Ribble Valley Borough Council
Council Offices
Church Walk,
Clitheroe
Lancashire
BB7 2RA

Phone: 0300 123 6780
Email: developeras@lancashire.gov.uk
Your ref: 3/2025/0614
Our ref: 3/2025/0614/HDC/KW
Date: 03 September 2025

Location: Higher College Farm Lower Road Longridge PR3 2YY
Proposal: Proposed change of use of the existing dwellinghouse (C3) to a small children's residential home (C2)
Grid Ref: 361561 437175

DRG NO.	REVISION
EAD_203_P_02	S1

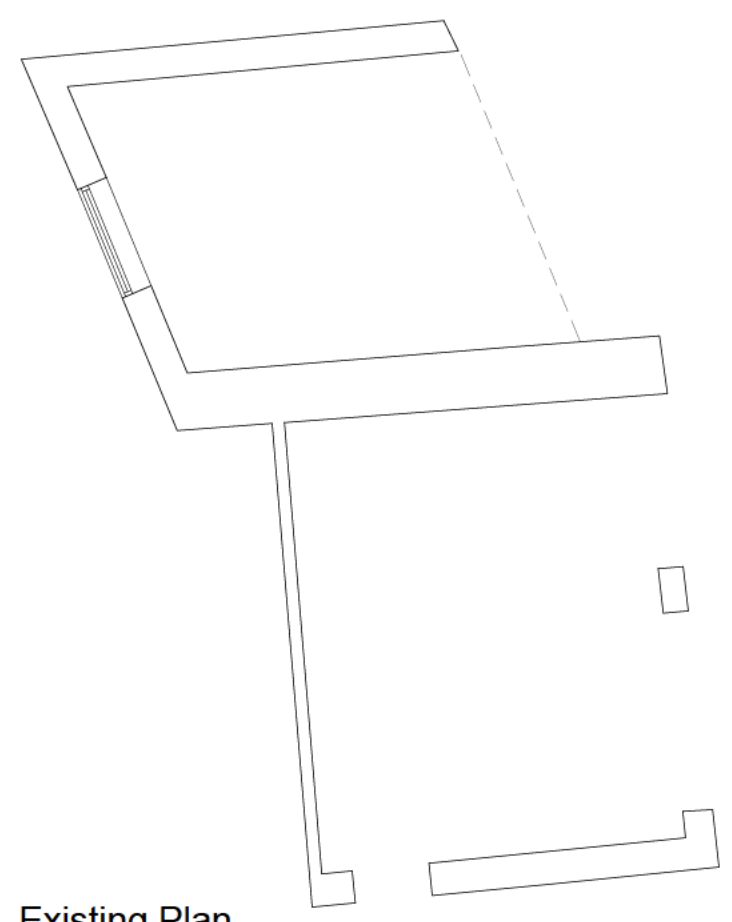
The LHA have reviewed drawing number EAD_203_P_02 Revision S1 and are aware that the proposal has 8 dedicated off-street parking provisions.

Taking guidance from advice provided by Lancashire County Council's Commissioner, which indicates that parking provisions should be provided at 1 vehicle per staff/child, plus 1 vehicle for the home, plus 1 vehicle for the manager, plus any external agencies which may visit the house. The proposal states that maximum capacity four children and five staff present therefore 5 parking spaces should be provided for staff, 1 additional space will cater for the manager, 1 additional space should cater for a vehicle for the home and 1 additional space should be provide space for an any external agencies or visitors.

As such the LHA would expect the development to have 8 off-street parking spaces which can be supported within the site as shown on the plans provided. There is also space to manoeuvre within the site, which will allow for ingress and egress in a forward gear.

1. The development hereby permitted shall not be occupied or brought into use until the car parking and turning areas shown on the approved plan(s) have been provided in full and are available for use. The car parking and turning areas shall thereafter be kept available for the parking and manoeuvring of vehicles at all times.
